Mountain View Electric Association, Inc. (MVEA) has these comments about the following:

**Project Name: Peaceful Valley Boundary Line Adjustment**

**Project Number: EXBL-17-001**

BOUNDARY LINE ADJUSTMENT
 A PORTION OF THE SW 1/4 OF SECTION 23,
 TOWNSHIP 15 SOUTH, RANGE 65 WEST OF THE 6TH P.M.
 COUNTY OF EL PASO, STATE OF COLORADO

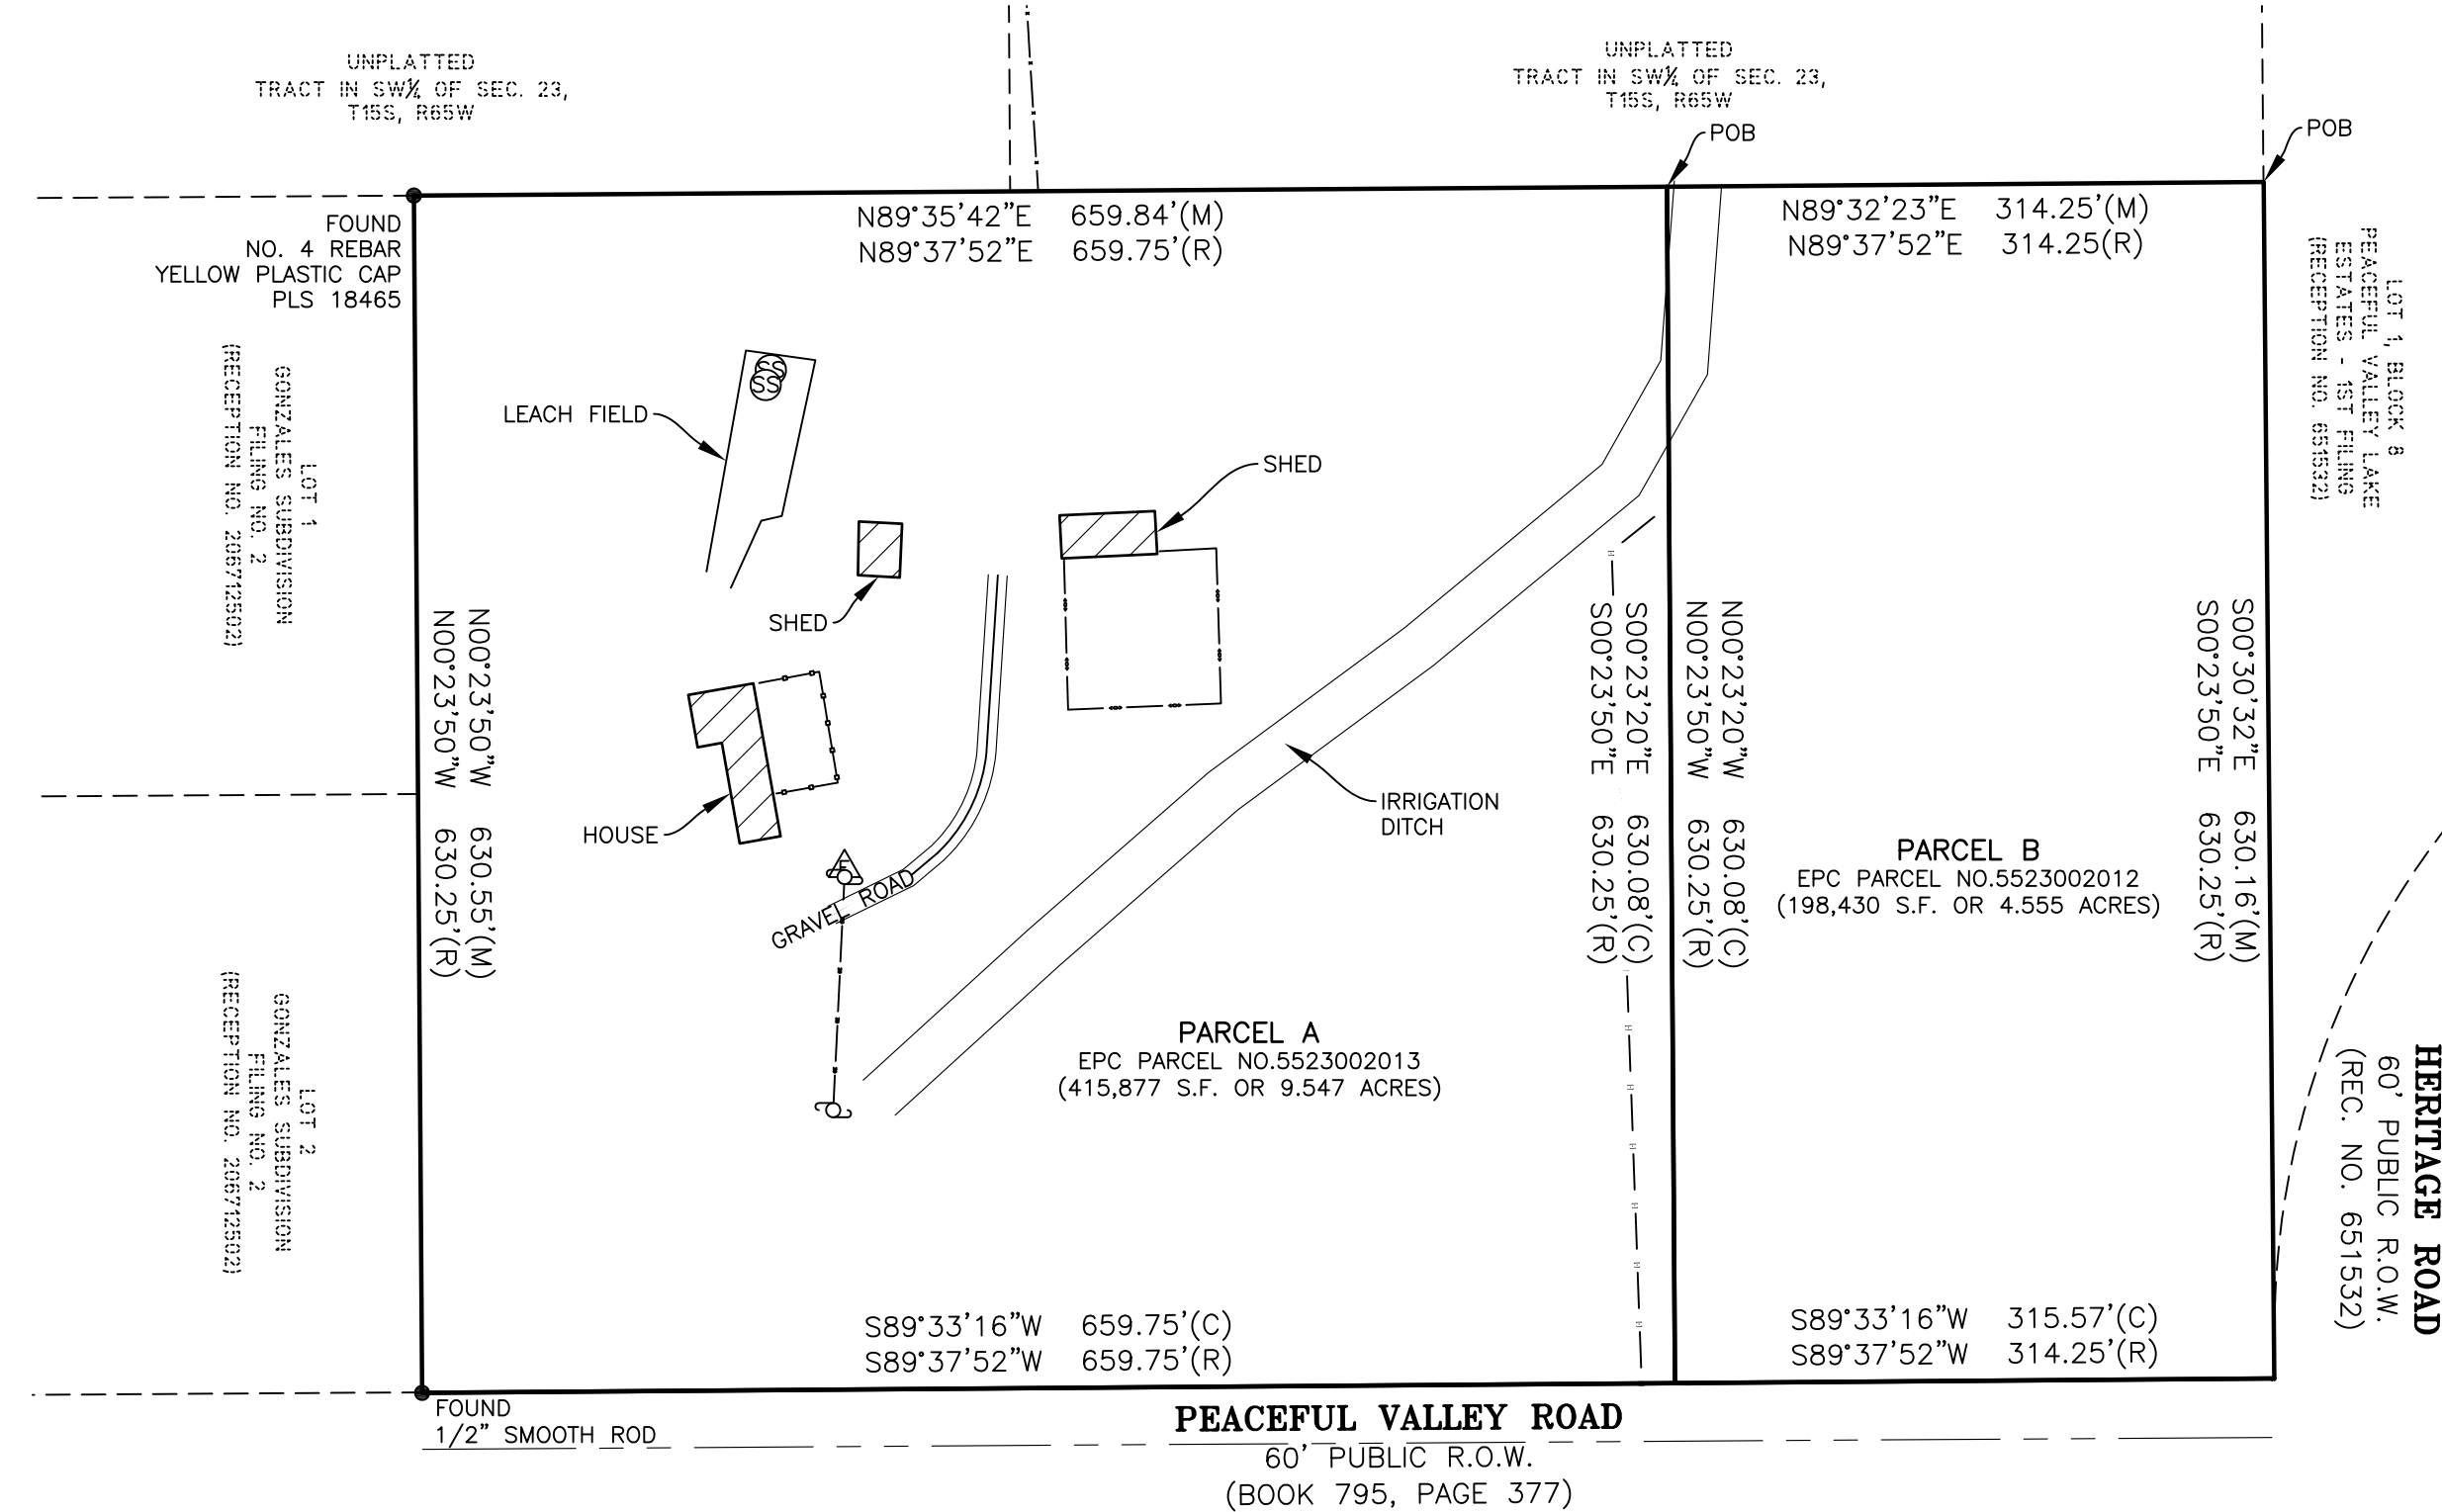
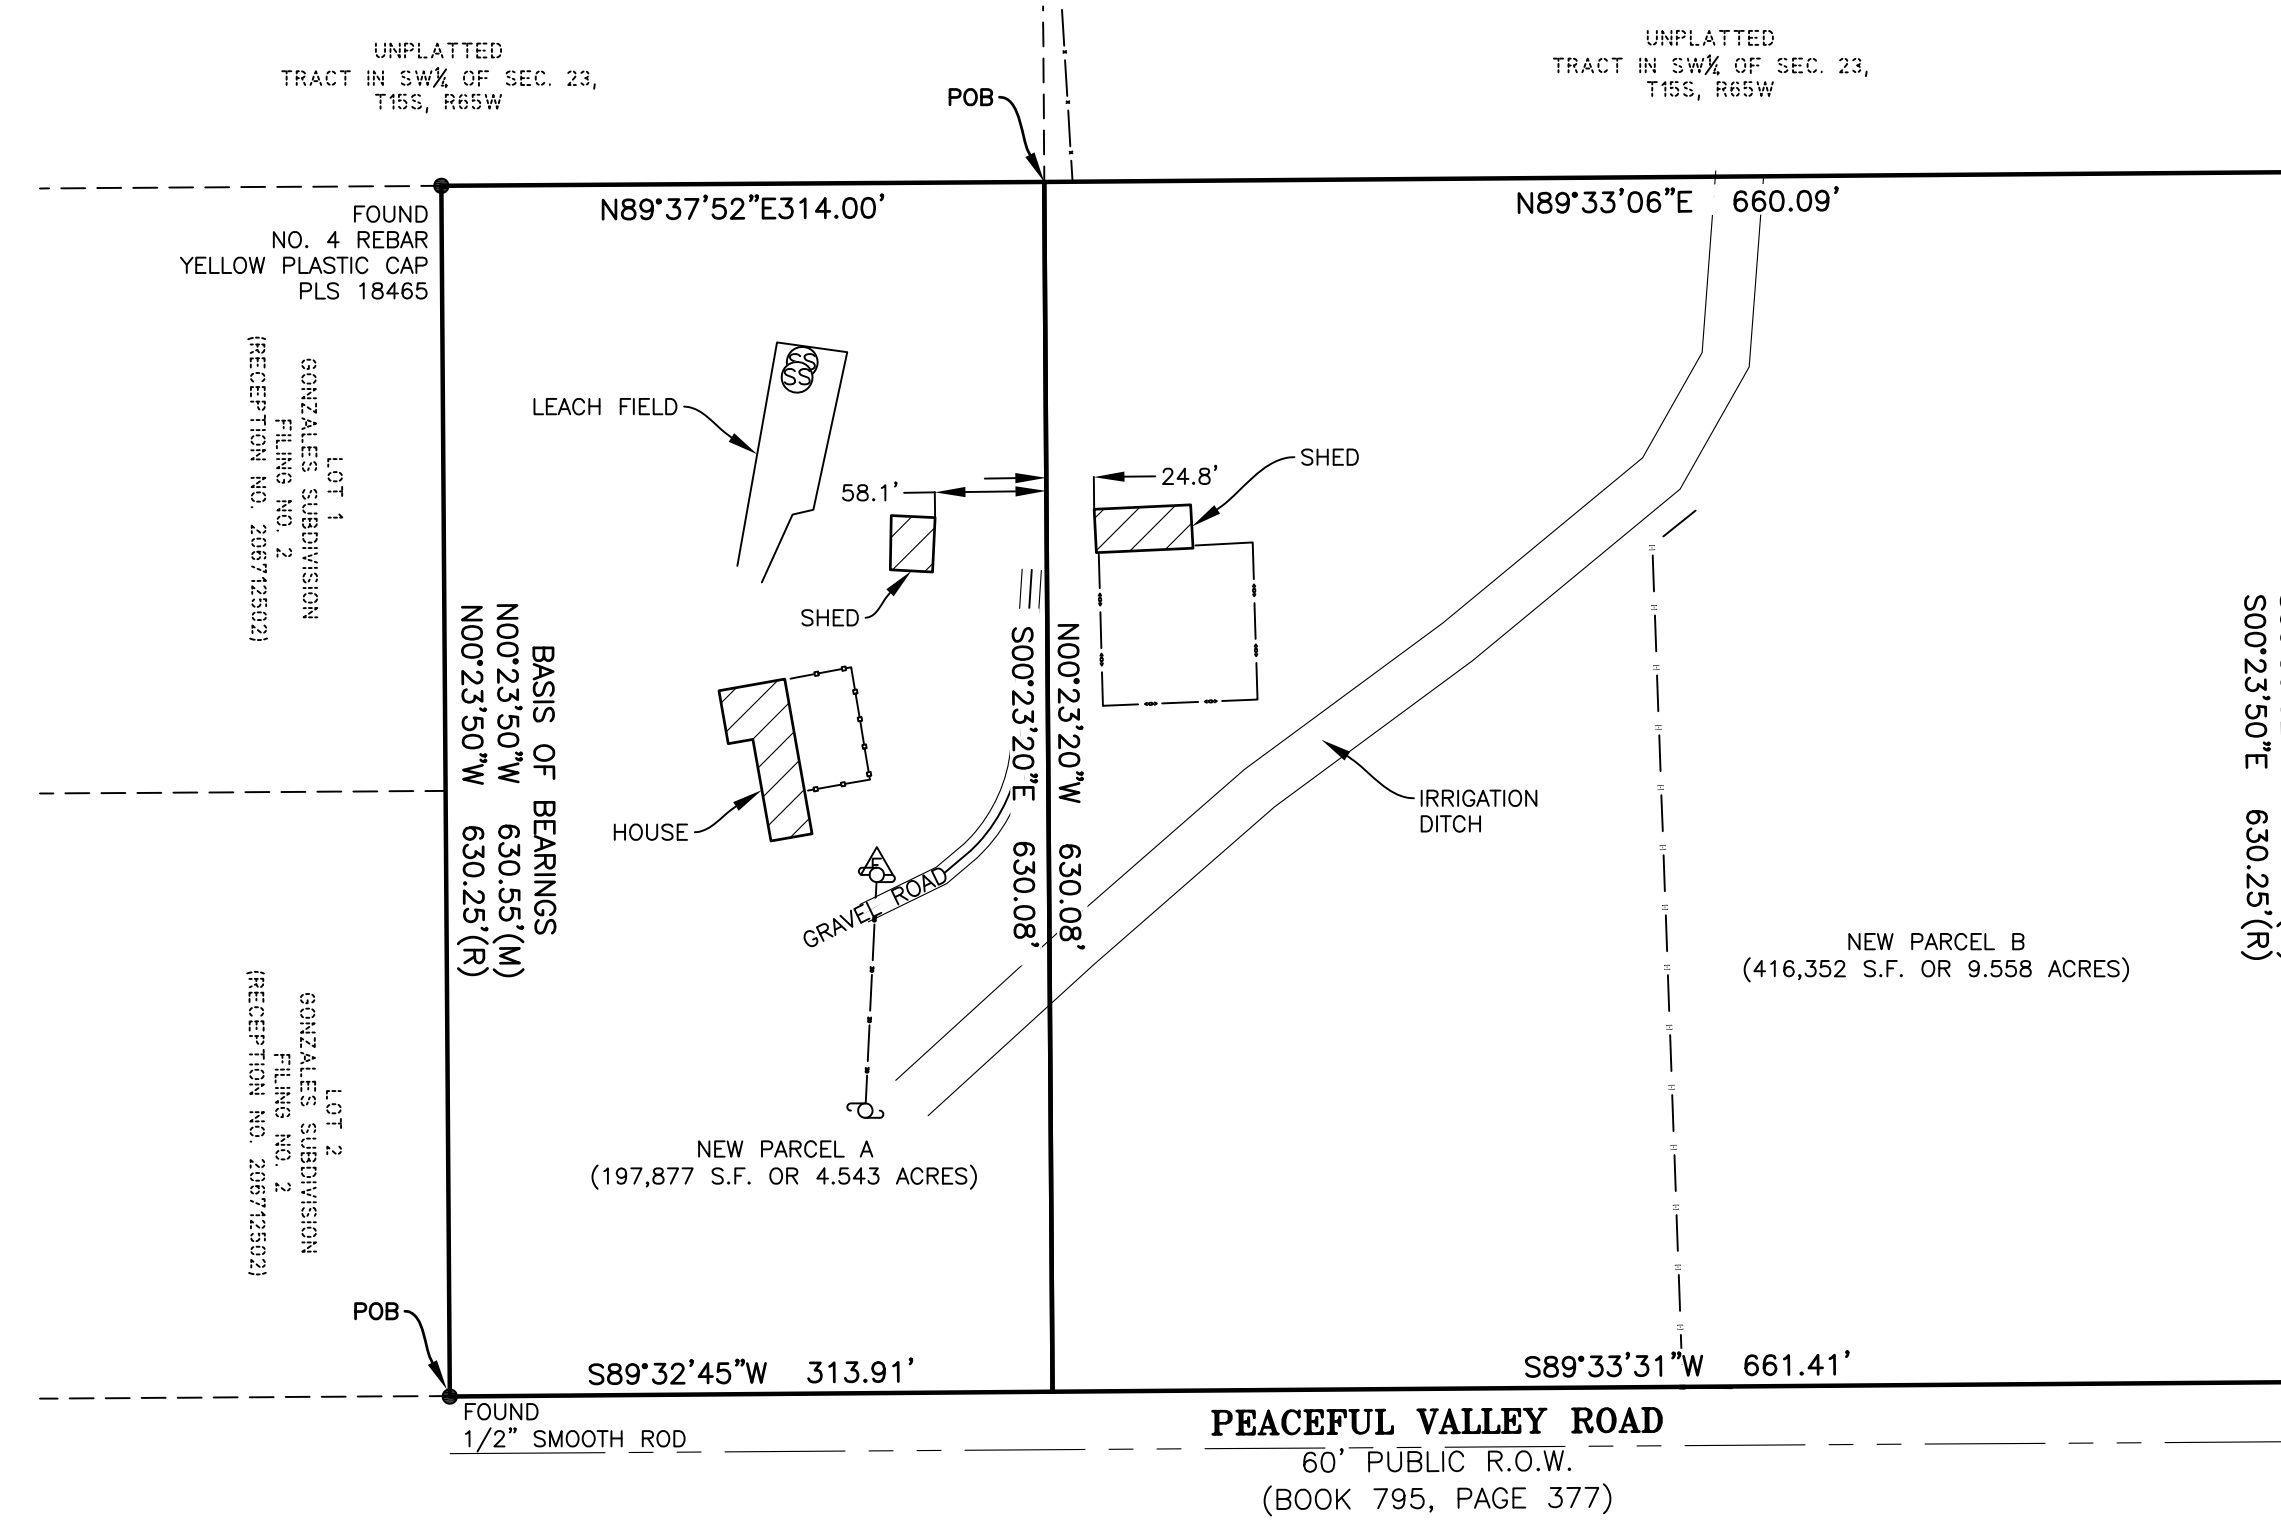
MVEA has no objection to the common lot line adjustment between these two residential lots with the understanding that MVEA has existing facilities near and within these parcels of land. If there is any removal or relocation of facilities it will be at the expense of the applicant. MVEA also requests platting of existing MVEA facilities with easement on the plat.
